DEPARTMENT OF PLANNING

SUBJECT: Section 75W modification request for the reorganisation of stormwater management devices at 61 Mobbs Lane, Epping (Former Channel 7 site) **(MP08 0258 MOD 1)**

PURPOSE

Title	OVERALL STORMWATER DRAINAGE PLAN
Drawing No.	7587-PA-14
Issue	D
Cad File No.	7587-PA-14
Xref.(s)

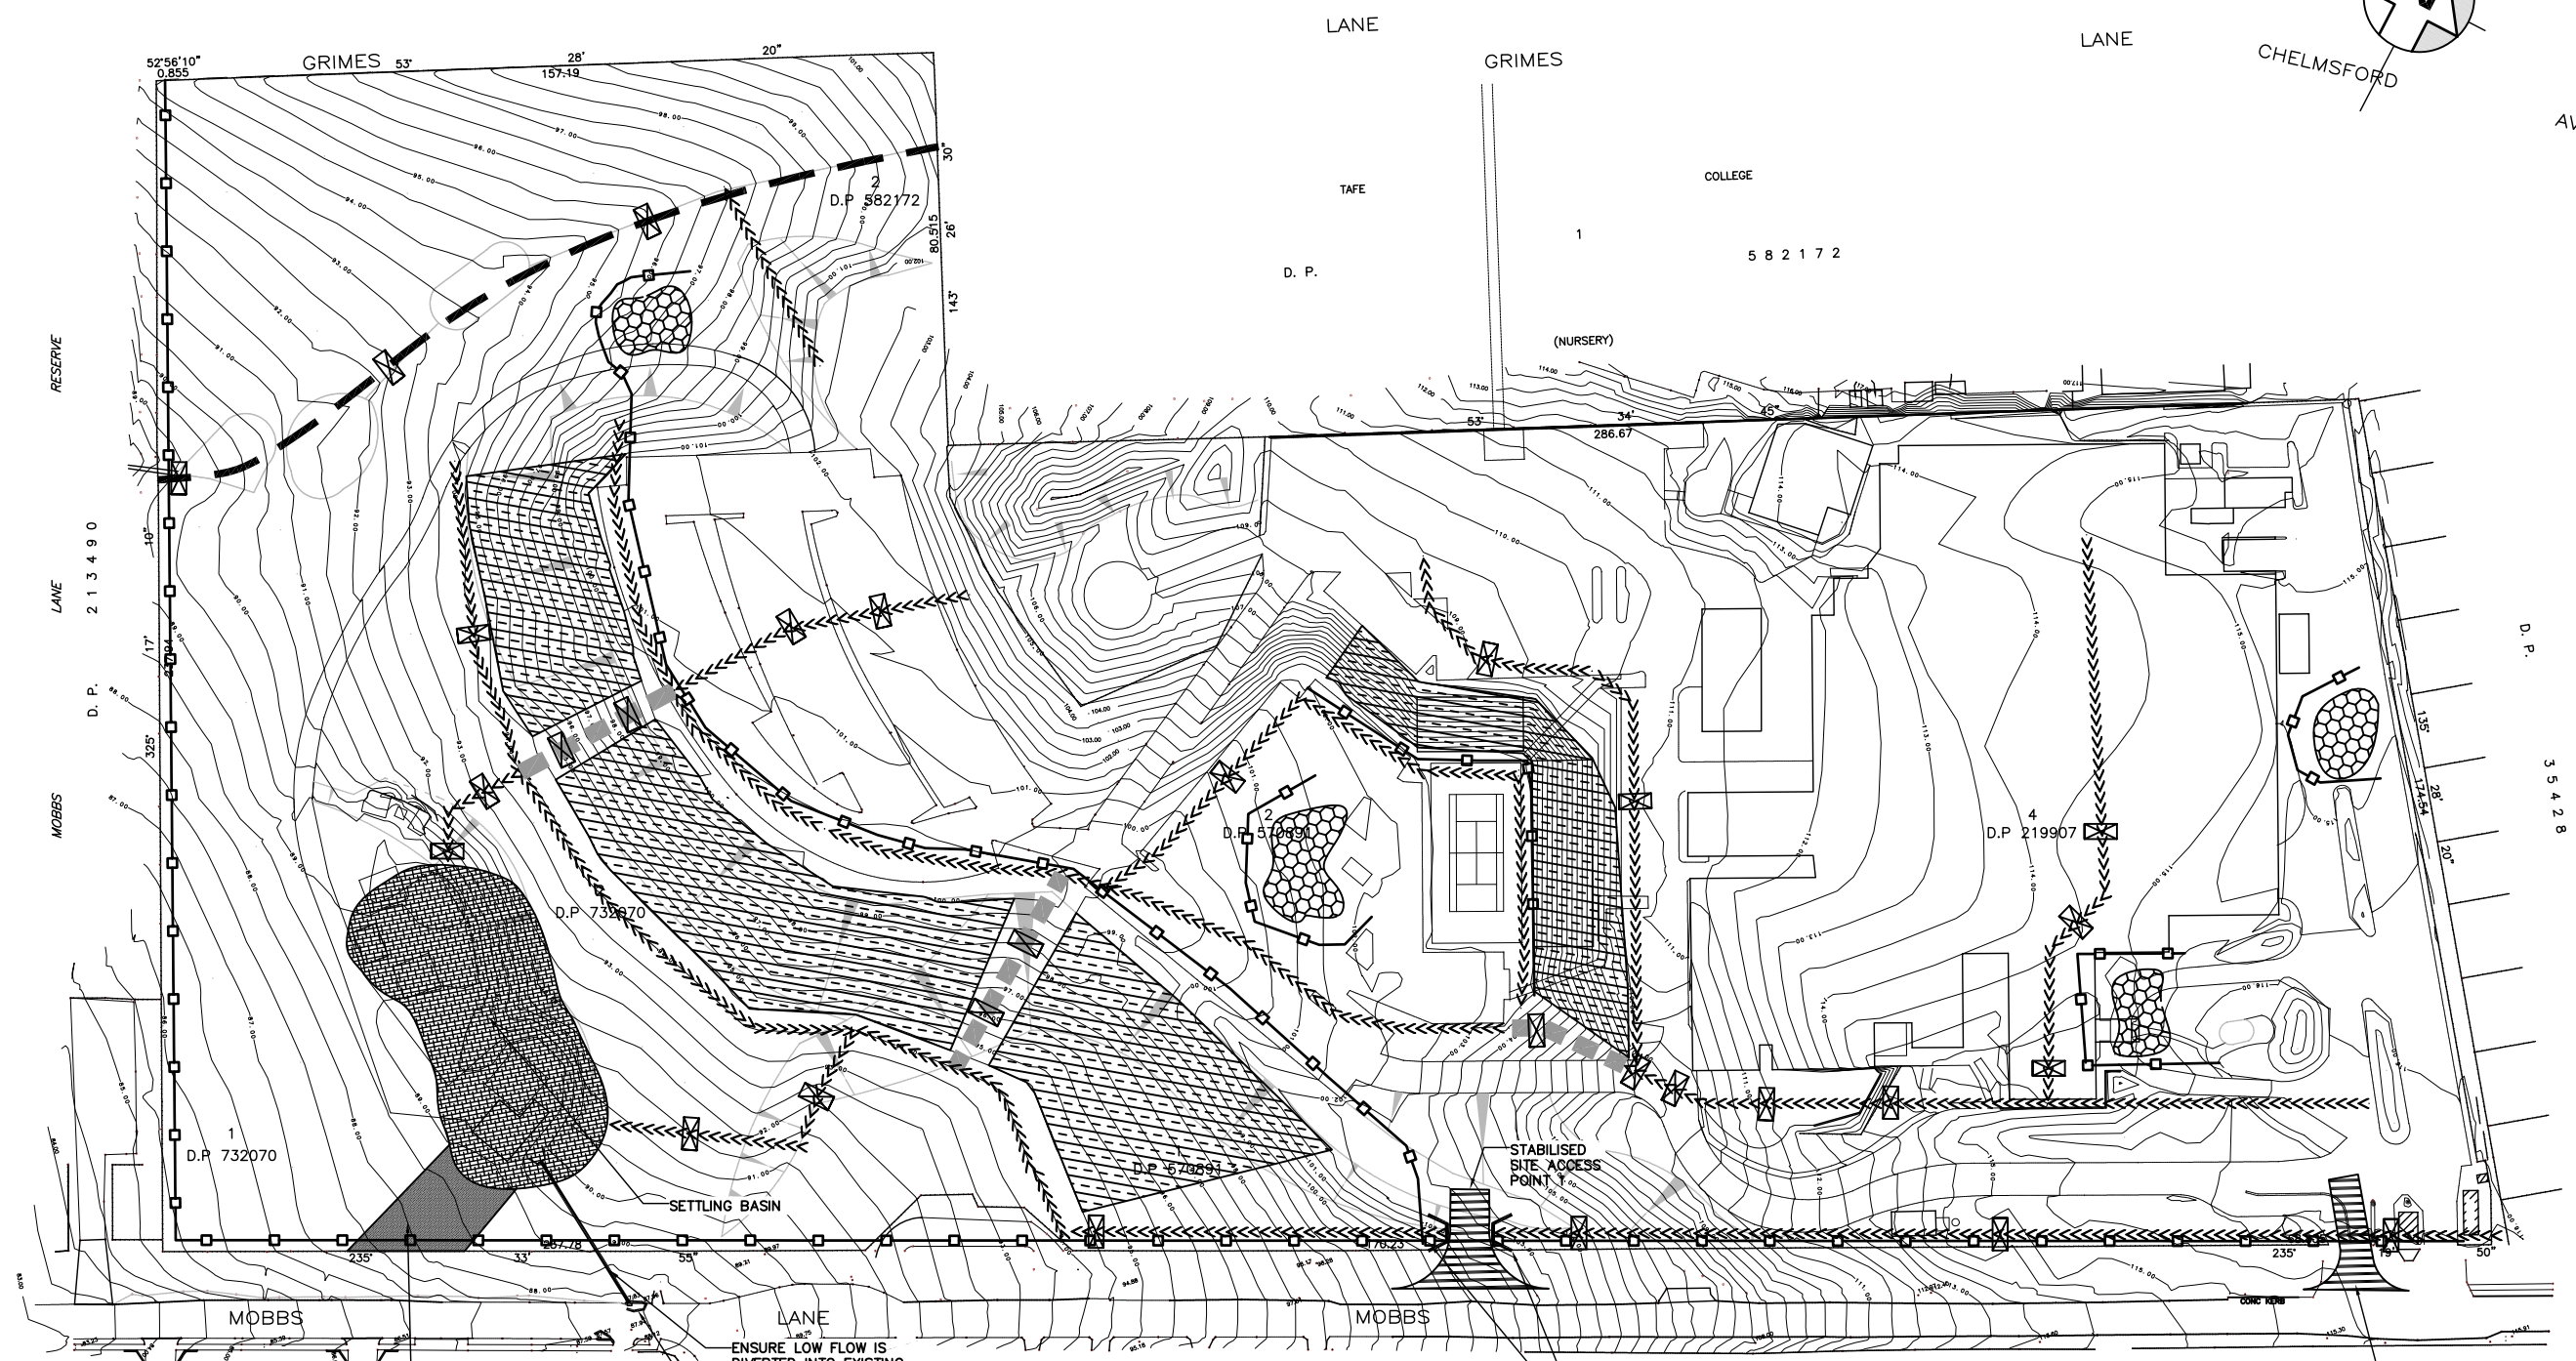
- **The proposal seeks to replace water sensitive stormwater systems with more traditional hard engineered drainage systems.**

- **The stormwater system will accelerate the conveyance and increase the quantity of flood flows to downstream areas.**

- **The proposed amendment is inconsistent with contemporary stormwater management practice.**

- The proposed system provides for a single end of line water sensitive system with the inclusion of a 2500m² water quality basin along with a number of Gross Pollutant Traps (GPT's) within the system. The basin has been modelled and meets the regularity requirements in the reduction of Total Suspended Solids, Total Phosphorus, Total Nitrogen and Gross Pollutants.

- Whilst the Department supports Water Sensitive Urban Design, the proposed modification will not adversely affect the stormwater management outcome as approved in the original consent and therefore does not object to the construction of kerb/gutters and underground piping to replace swales and 'rain gardens'. Condition B20 –

Stormwater and Drainage Works, will remain in force which requests the details to be submitted to Council demonstrating compliance with Council's Local Floodplain Risk Management Policy; Stormwater Design and Development Guidelines; and the Local Development Control Plan, prior to a Construction Certificate being issued. It is also noted that Council did not raise an objection to the proposed modification.

- The amended proposal does not seek to change the original on site detention (OSD) system. The quantity of OSD is equal to the volume of that originally approved. The OSD is wholly contained within the proposed basin.

- The Department considers the stormwater system, as modified, will provide on site detention with an equal outcome to that which was originally approved under the original application and therefore the influence on downstream flooding will not change as a result of this modification.

- The stormwater quality objectives adopted from Parramatta Council's DCP (2005) have been achieved.

- Condition B20 – Stormwater and Drainage Works (as described above) is still valid within the approval therefore the Department is of the opinion that Parramatta Council will ensure all plans meet Council's expected standard of management practice.
